This email corresponds to P/66/20/TEL

This application is for the erection of a 17.5m monopole with wraparound cabinet at base and three additional cabinets at ground level. The site is located on Chalcraft Lane, a C-classified road subject to national speed limit in this location.

West Sussex County Council – Planning Services

Title: 215 MAXIMUM CONFIGURATION
SITE PLAN

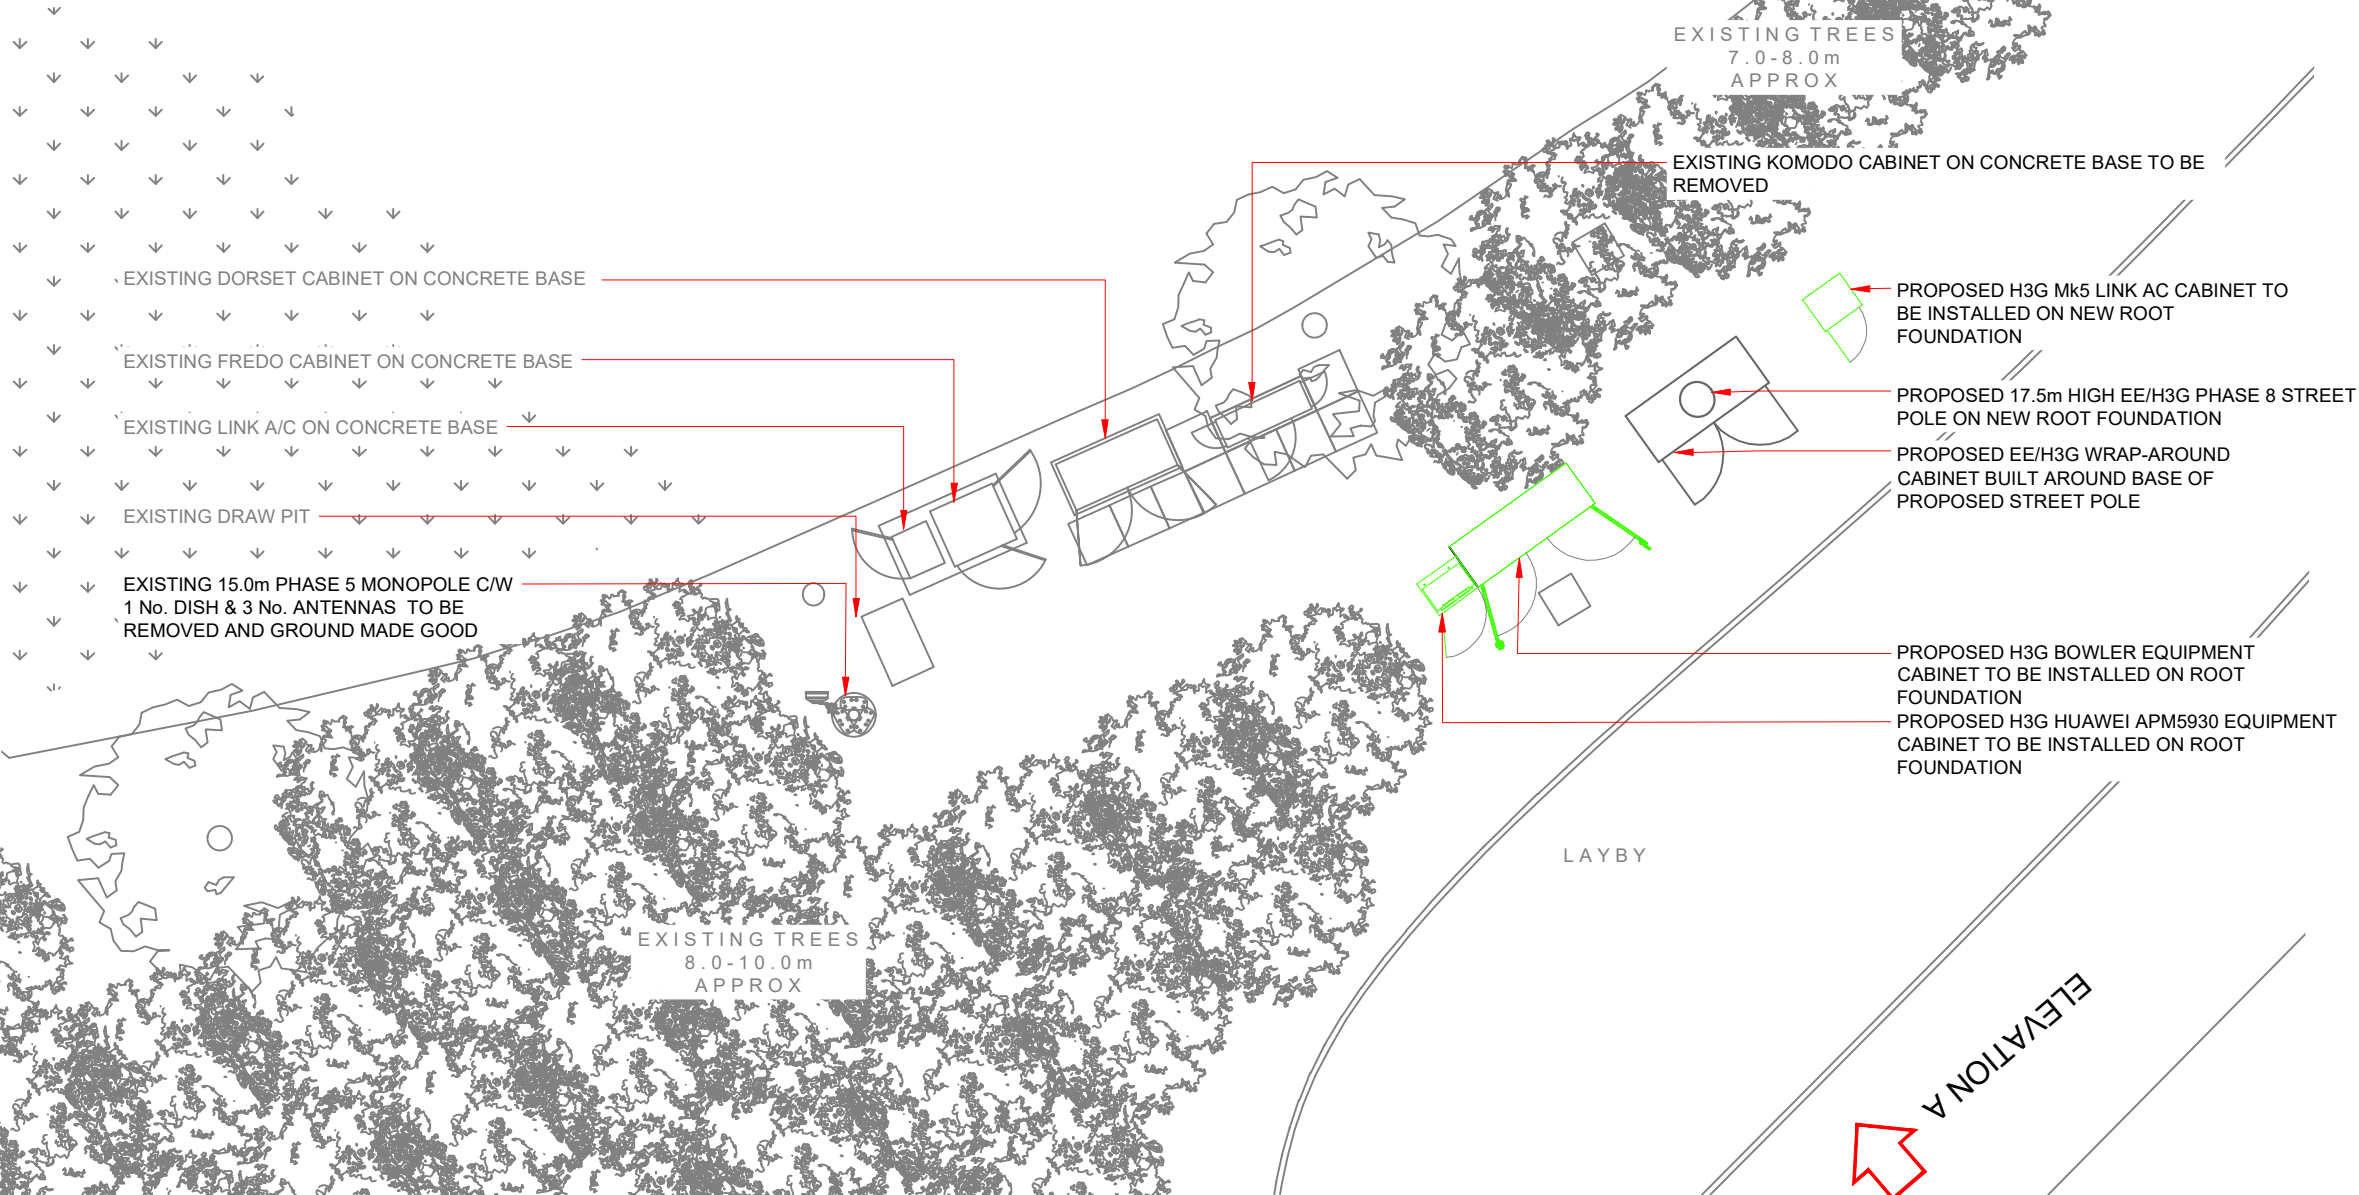
The proposed cabinets and pole will be located on the verge of Chalcraft Lane, within the public highway. This location is not anticipated to result in any obstruction to visibility for vehicles travelling along Chalcraft Lane and due to the lack of footway in this location, is not anticipated to obstruct pedestrians.

The statutory undertaker will need to submit the necessary notification to the Highway Authority independently and any traffic management will need to be agreed with WSCC Highways prior to works taking place. Their contact details are included below.

The Local Highways Authority (LHA) advises the applicant that in addition to obtaining planning permission that they must also obtain formal approval from the highway authority to carry out any proposed works on the highway, please call 01243 642105.
